# ***City of Albuquerque***

December 19, 2001

**RE: Grading and Drainage Plan for Mr. B's Paint & Body Shop (L18-D64) Dated  
December 11, 2001**

A PROPOSED GRADING AND DRAINAGE PLAN  
FOR  
MR. B's PAINT AND BODY SHOP, INC.  
(1410 VALENCIA DRIVE, S.E.)  
ALBUQUERQUE, NEW MEXICO  
OCTOBER, 2001  
(REVISION: DECEMBER, 2001)

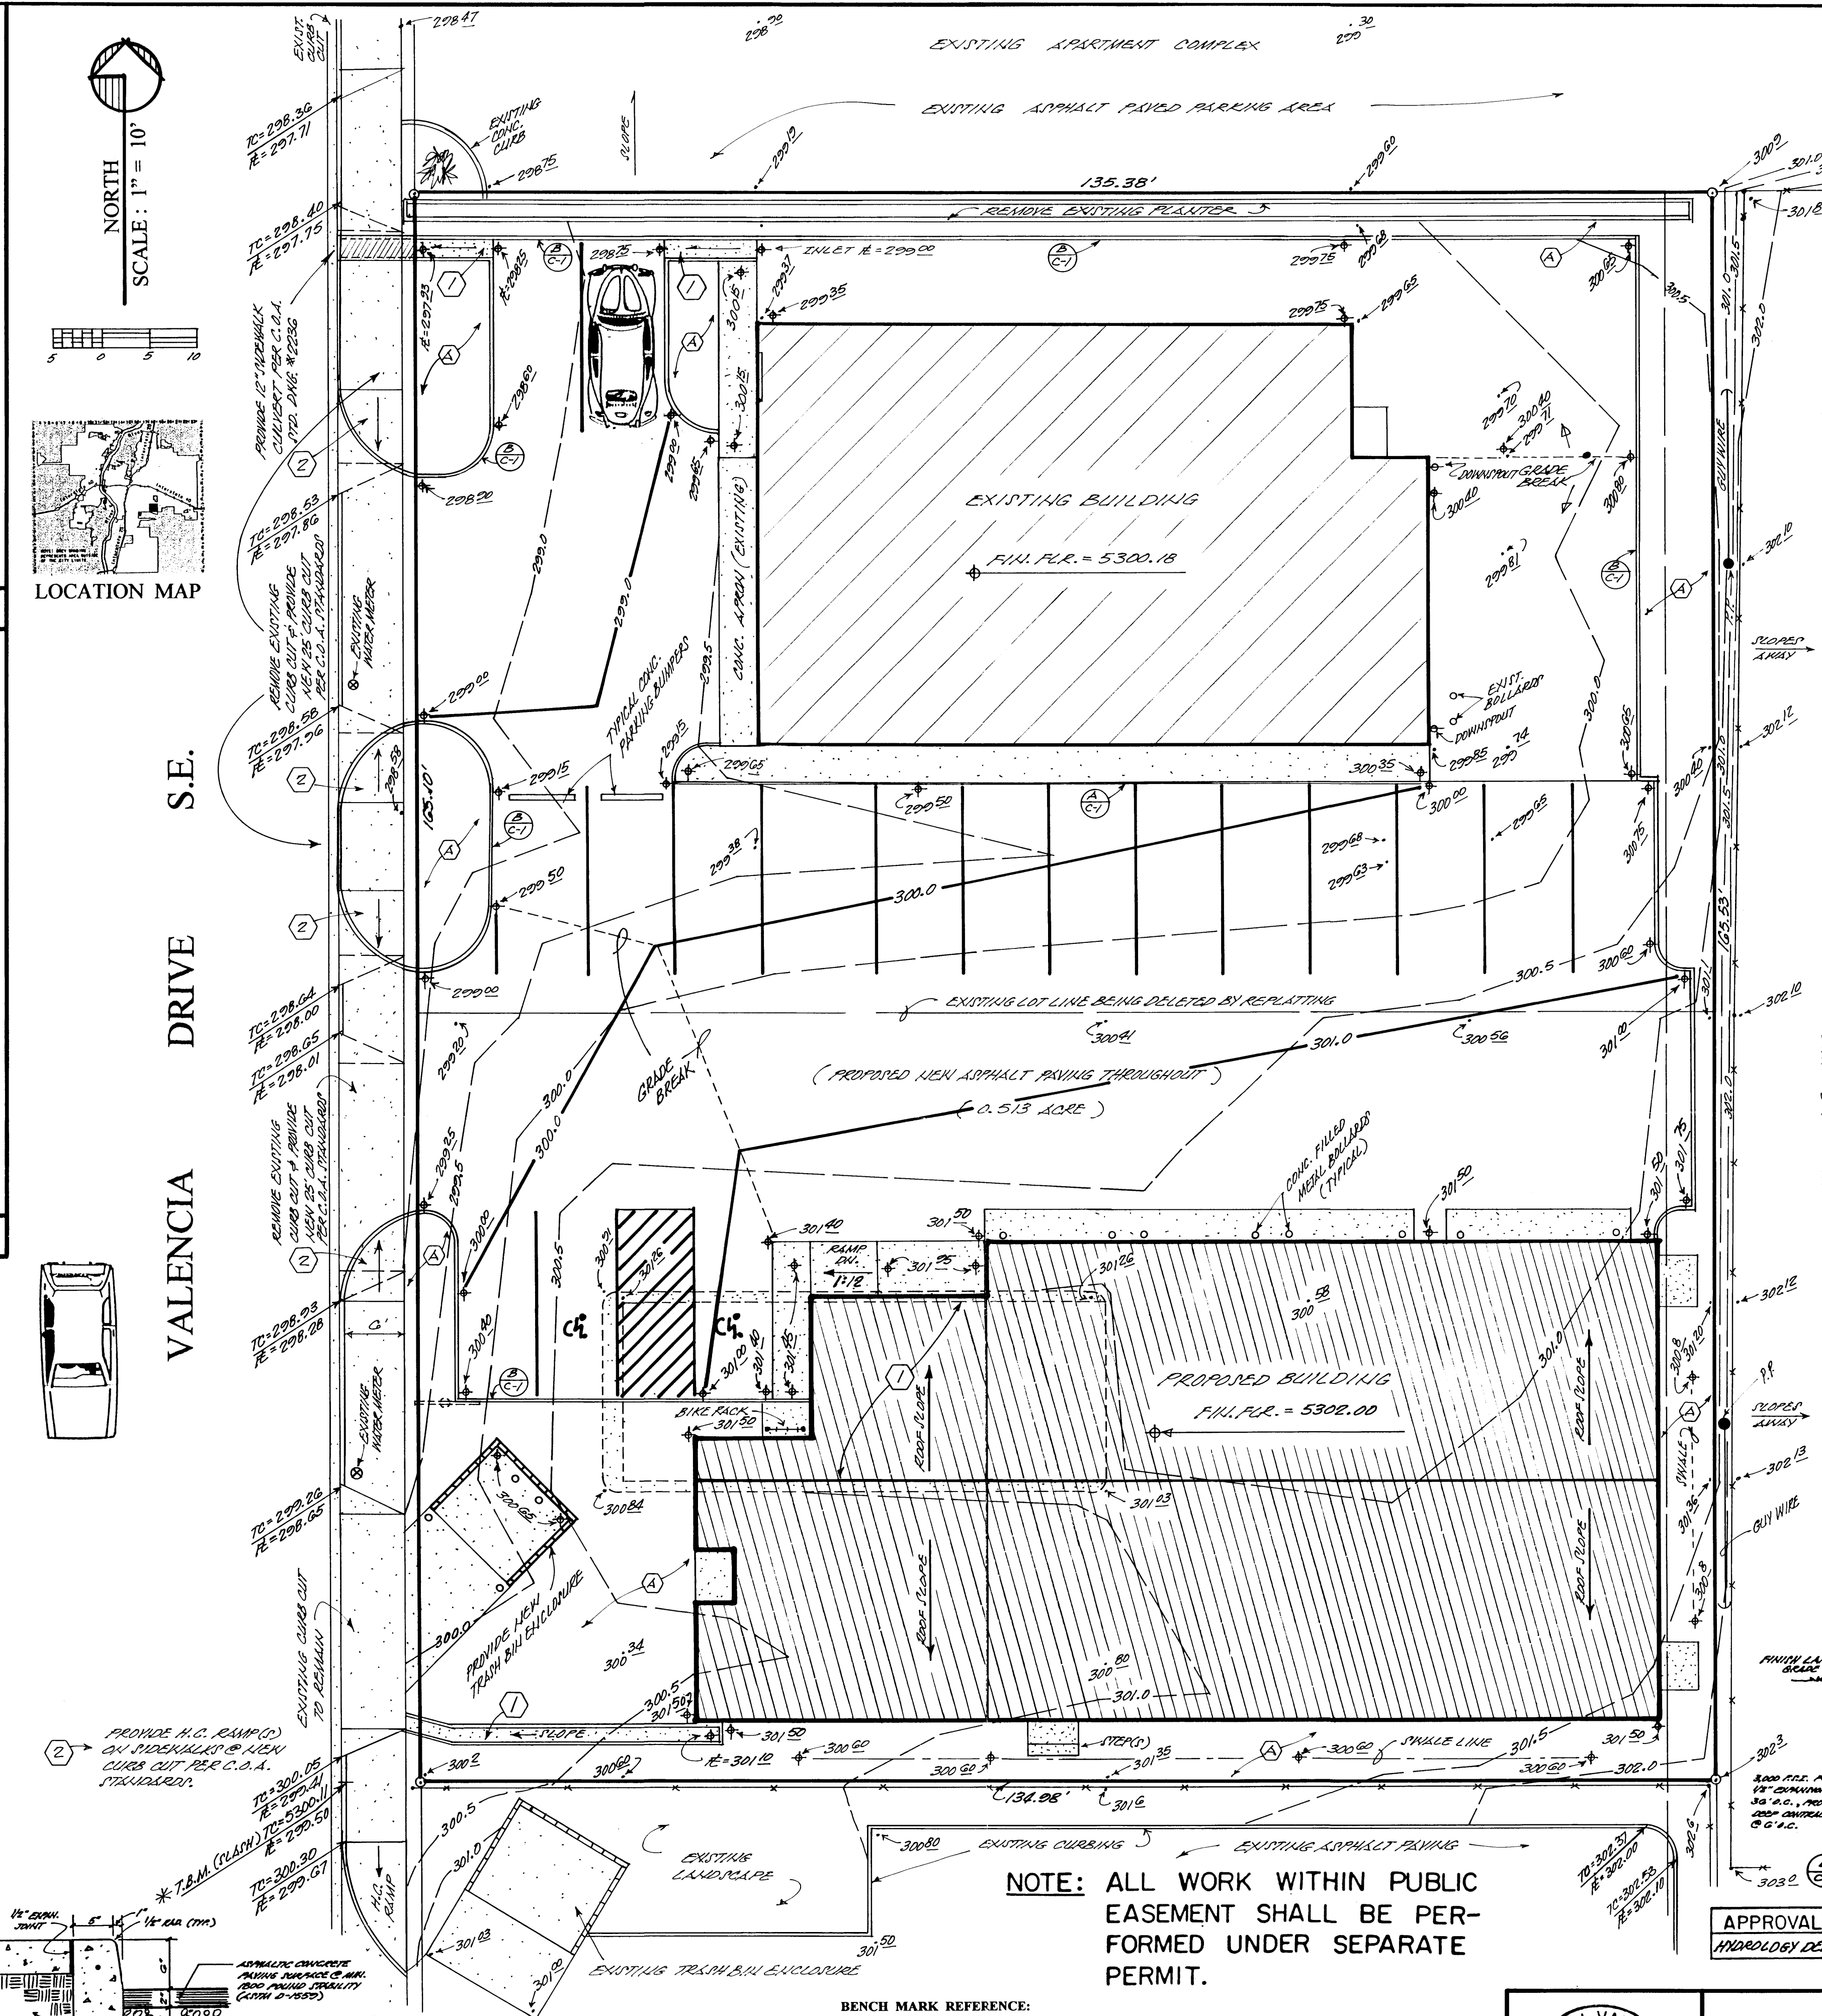
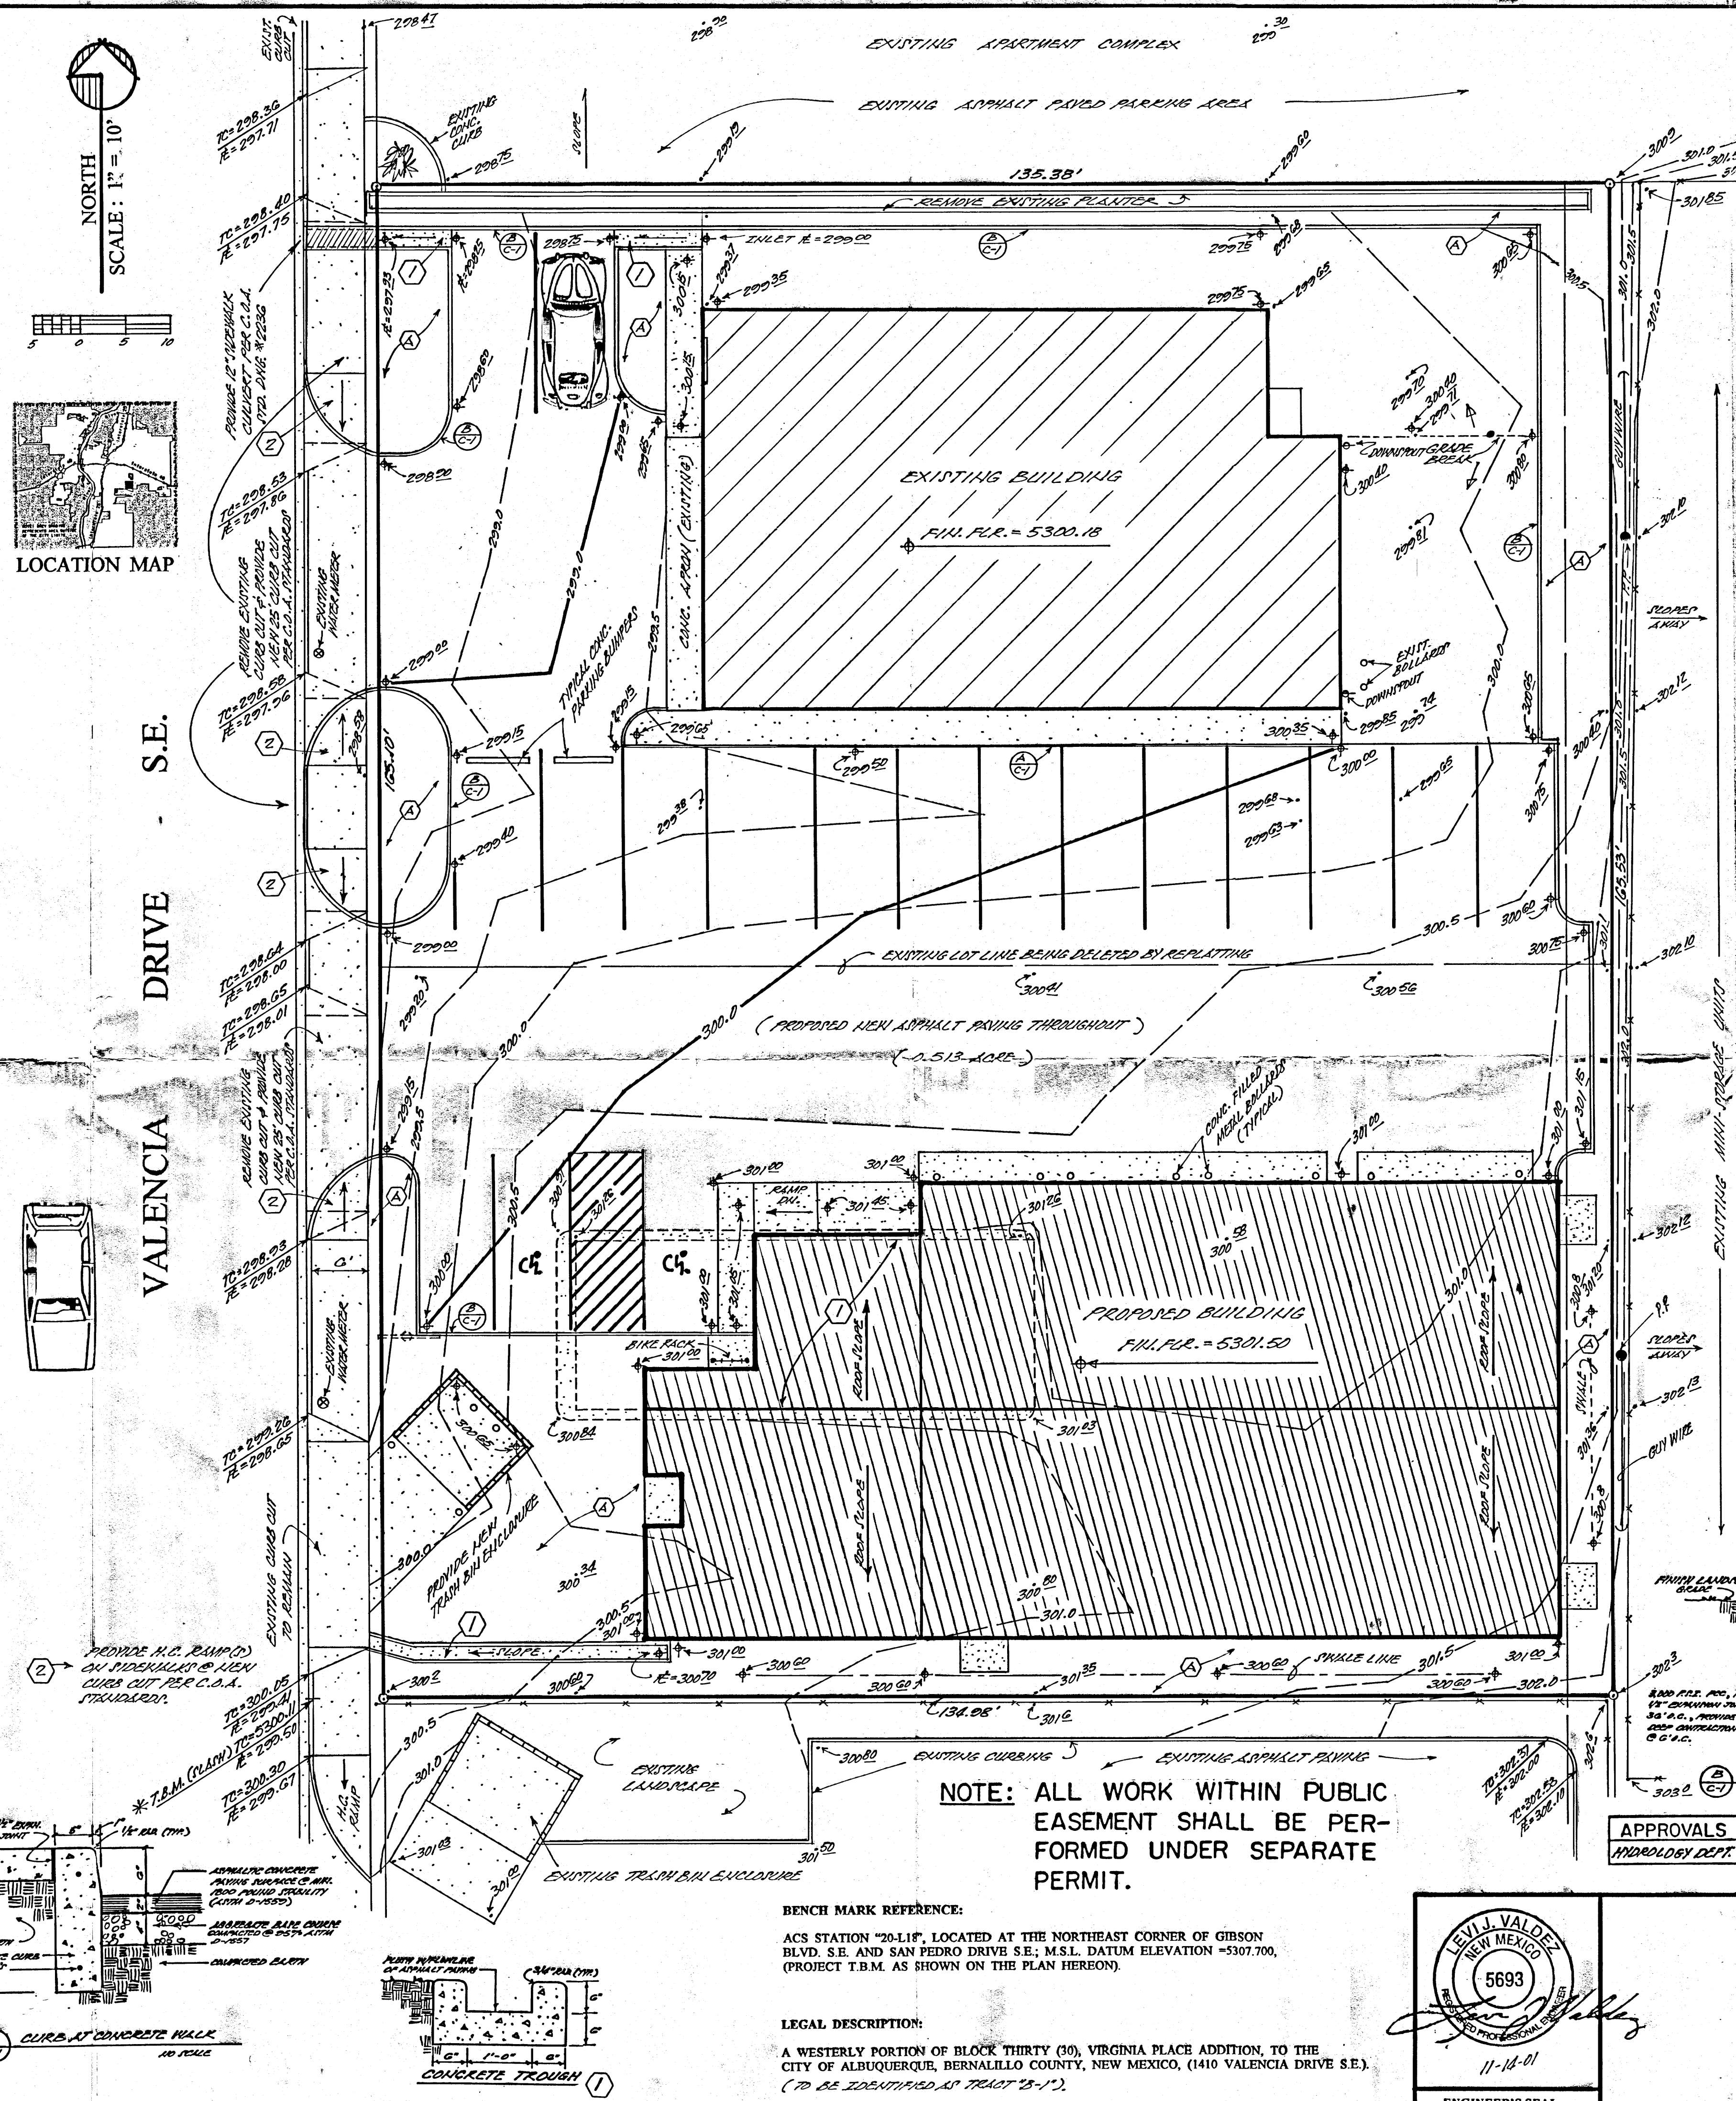
I wanted to update you on the floodplain approval. Per the Floodplain Ordinance you need to have the finish floor two feet above the adjacent ground. The owner may need to pay a higher rate of flood insurance because the finish floor is at a lower elevation. You may still want to talk with the owner about his options. I did allow the lower finish floor because of three drainage systems built upstream of your site that are not reflected in the floodplain maps. I have attached three facility maps that show the systems. The existing drainage systems are the San Mateo storm drain, the Gibson storm drain, and the Kirtland Dam. These systems should remove the floodplain or reduce the depth of runoff. However, the maps still have not been changed.
